George Hotel

26.07.09 - S73 Variation – Overview Report

Planning Consent – Condition 2 (T&CPA Section S73)

- Planning Ref: 2025/48/91147/W (Condition 2 Approved Drawings) dated 24.10.25

1 Proposed GA Elevation - John William Street
1 : 100

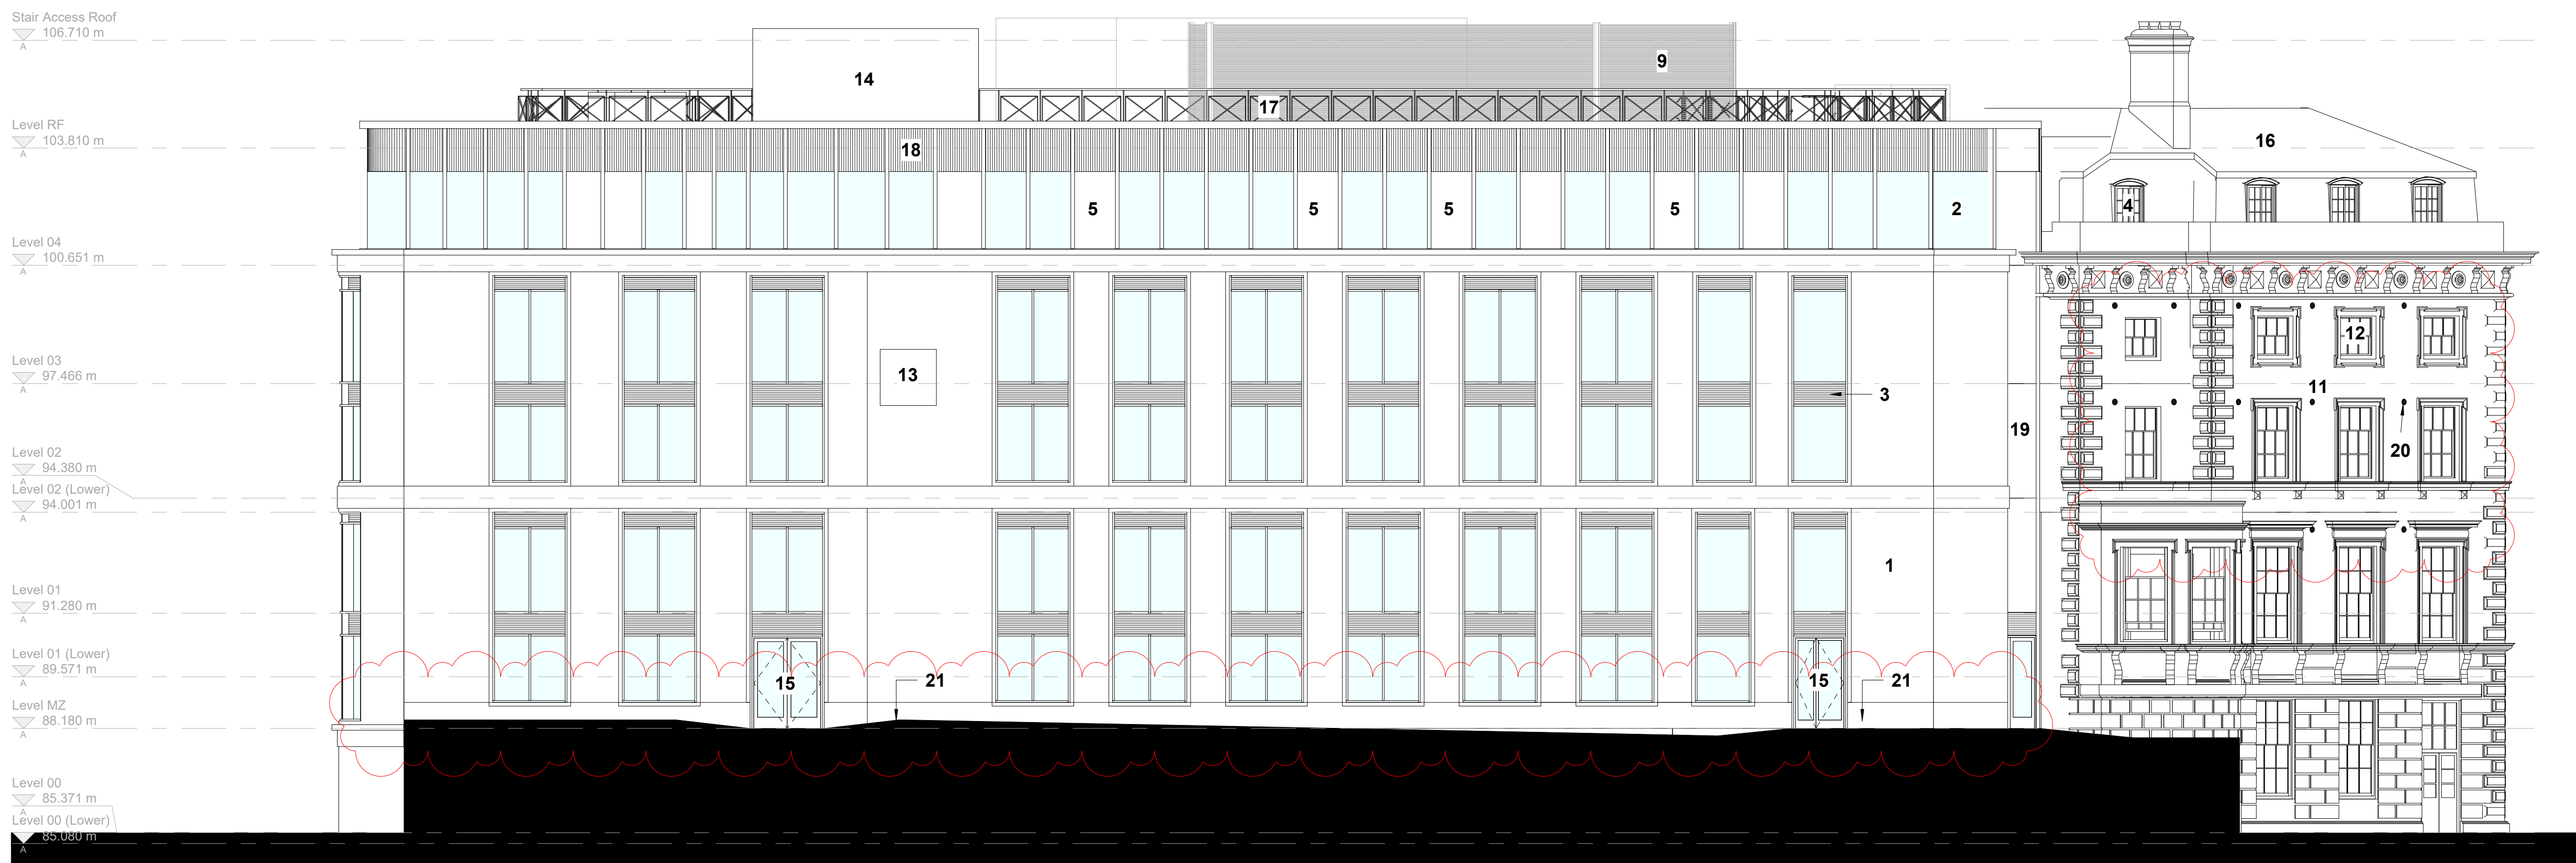
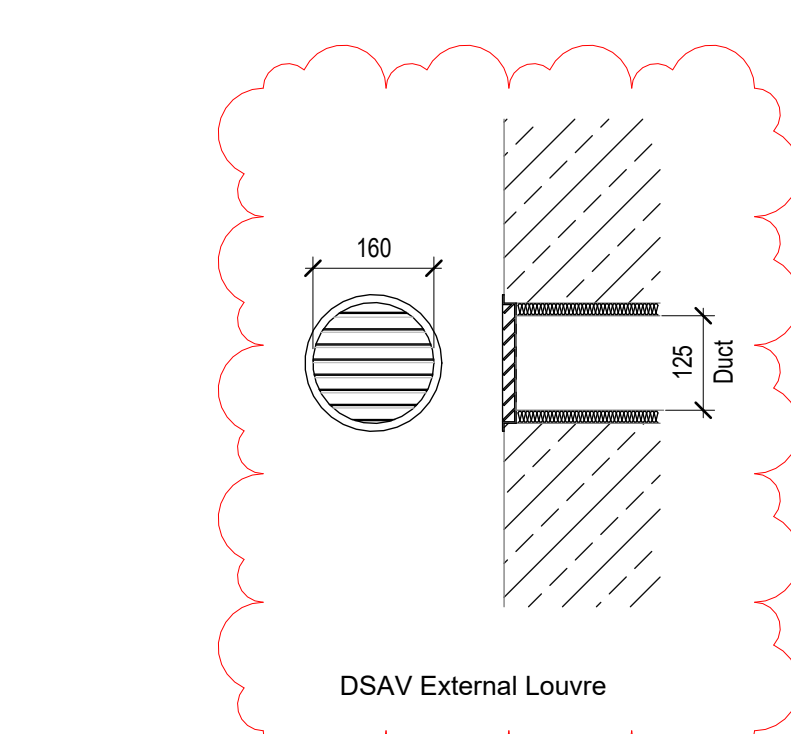
1. Rooftop plant enclosure and plant screen reconfigured to provide acoustic screening to rooftop plant.
2. Ventilation grilles added to Block A as a result of the MEP ventilation strategy developing through to stage 4.
3. Additional ventilation grilles added to JWS as a result of the MEP ventilation strategy developing through to stage 4.
4. Plinth added to west elevation of new build to raise cills above damp proof course.
5. Plinth added to east elevation of new build to raise cills above damp proof course.

- List of plan changes:**
- 1. LV Plant Room relocated to ground floor.
 - 2. Bike Store relocated.
 - 3. Male & female change relocated.
 - 4. Pump & tank room relocated.
 - 5. Canteen and GM office relocated.
 - 6. Accessible WC relocated.

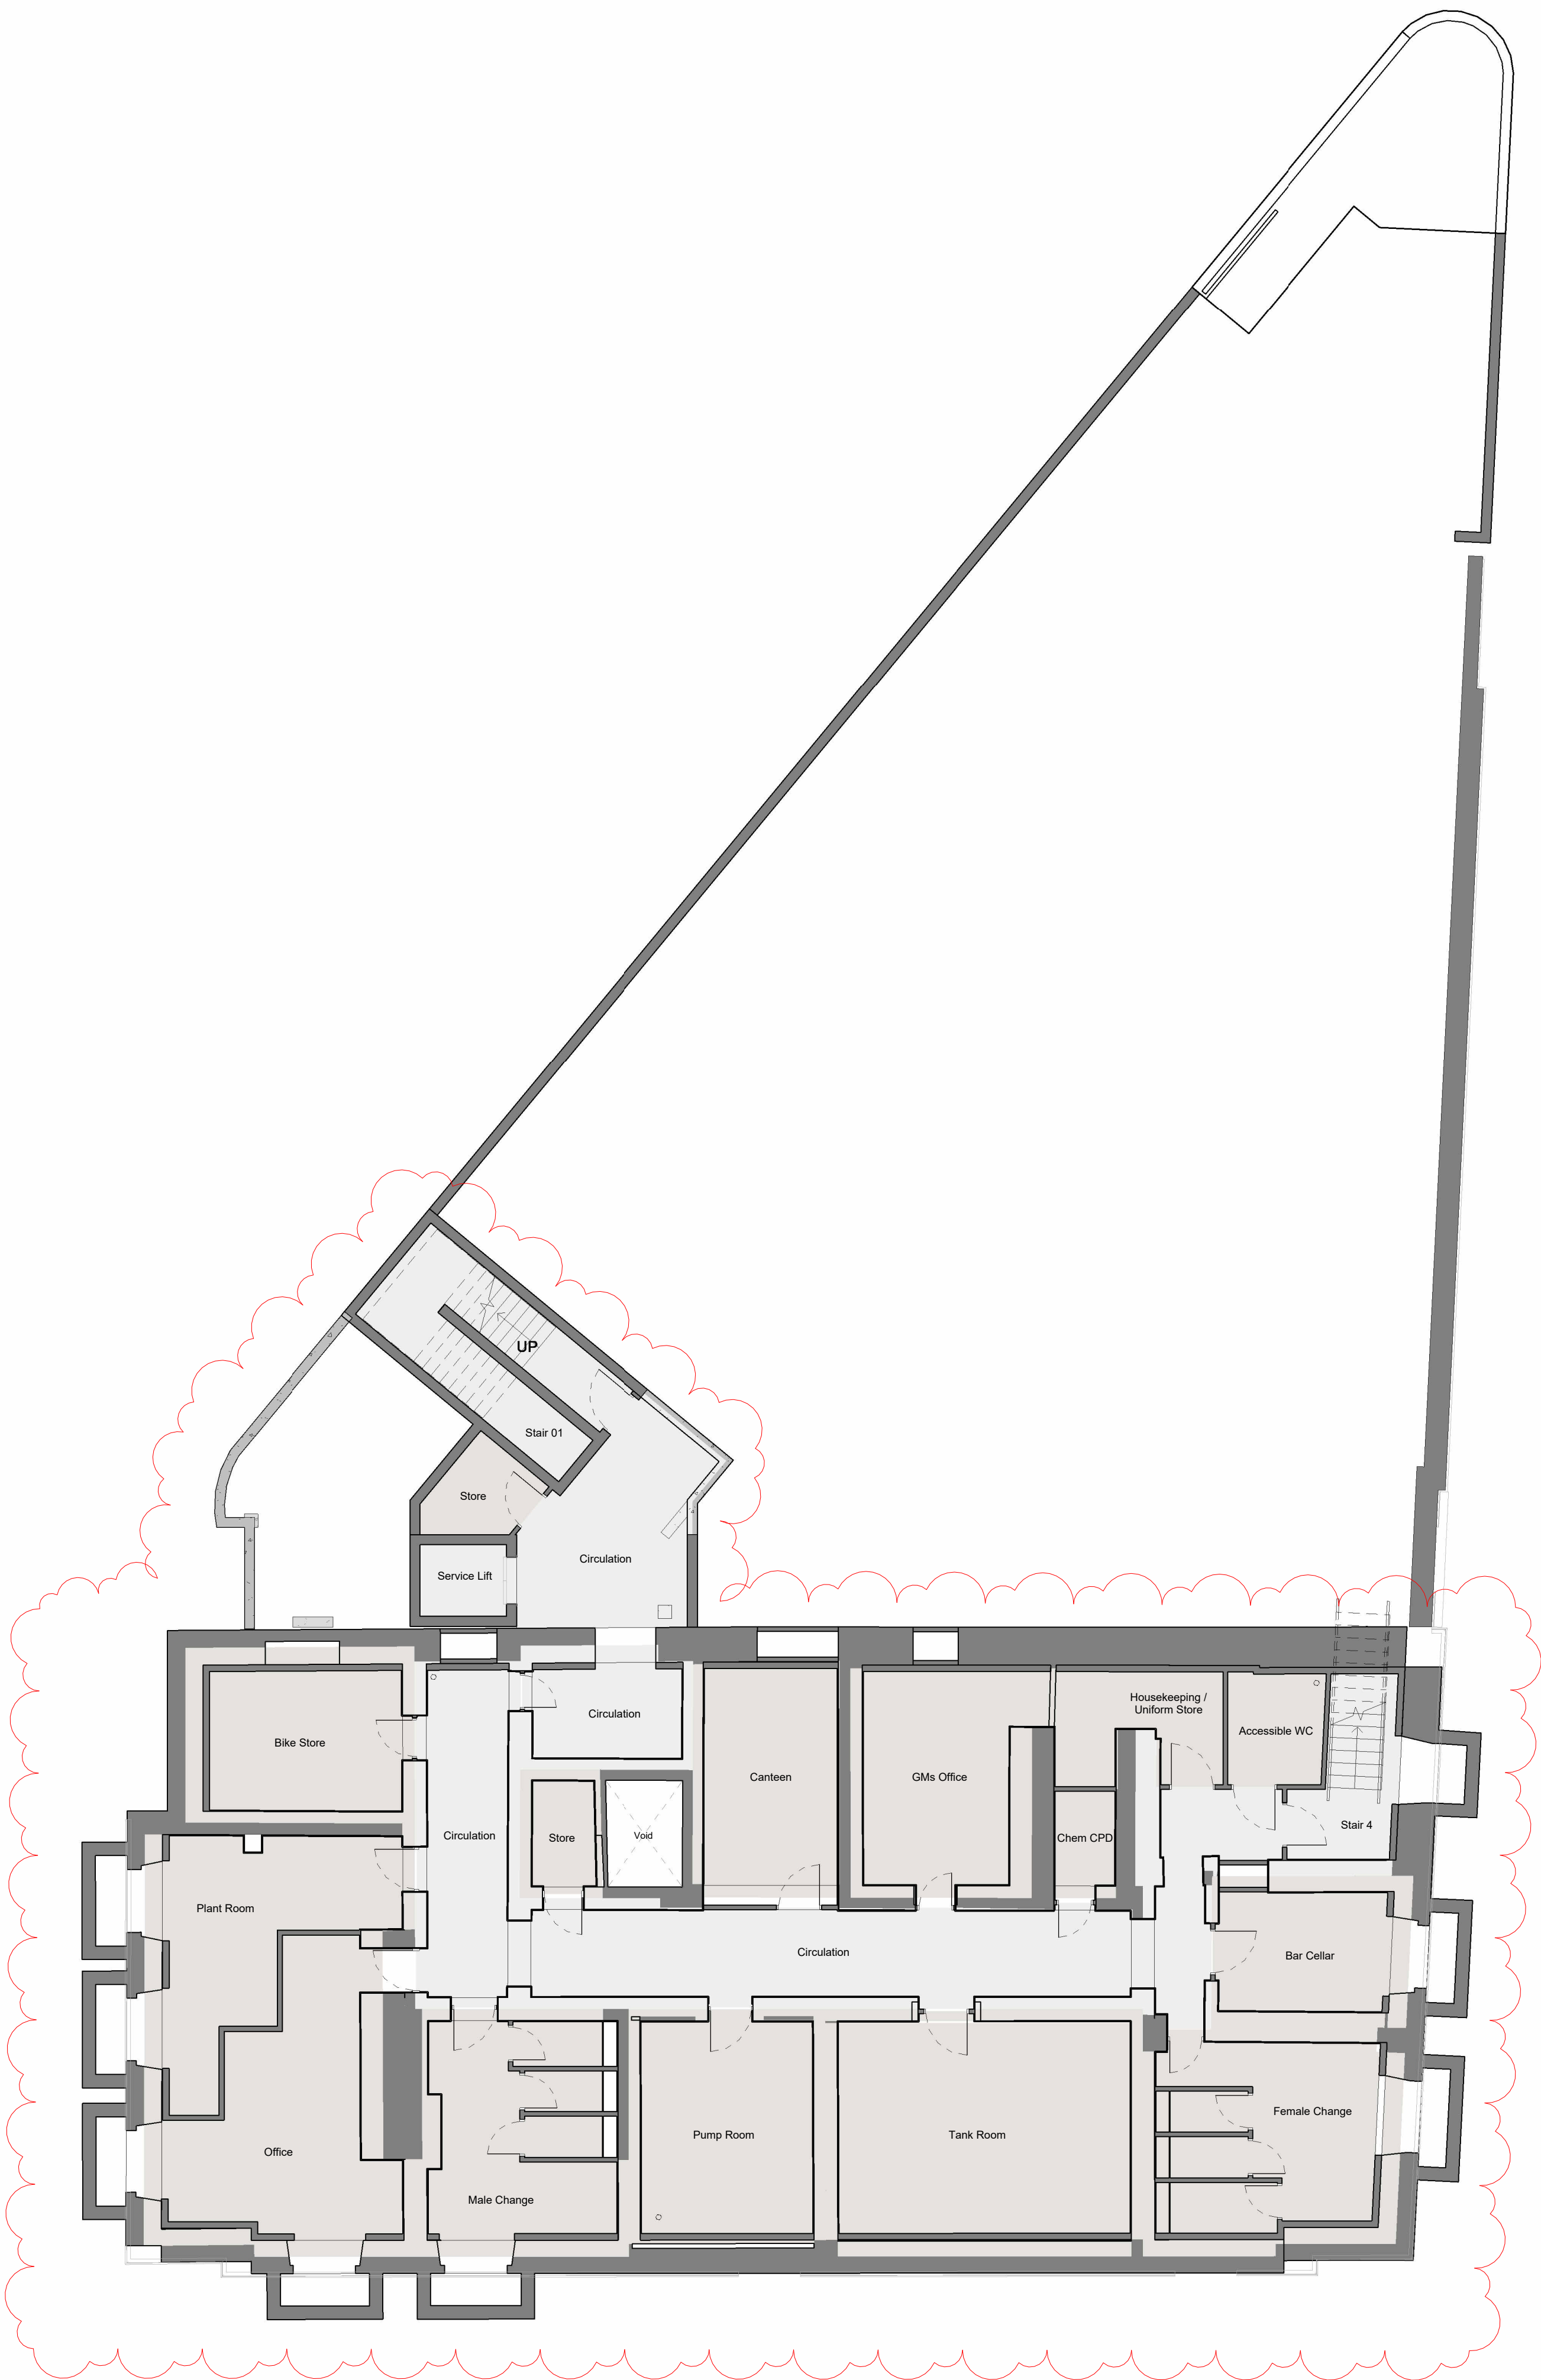
1. Existing floor slab removed (mixture of levels, materials & condition) and replaced with a new concrete basement slab along with relevant waterproofing/ water control systems.
2. LV Plant Room relocated to the Ground Floor where the linen stores were previously (under current approvals).
3. Bike Store relocated on the plan – volume and commitment unchanged noting location is an improvement due to proximity of staircase and lift.
4. Male & Female change relocated on the plan
5. Pump & Tank room relocated on the plan
6. Canteen & GM Office relocated on the plan
7. Accessible WC relocated on the plan
8. New AOVs to be installed within the existing window openings
9. Supporting steelwork installed at high level to the main central corridor to provide additional support/ structure to the span stone slabs.
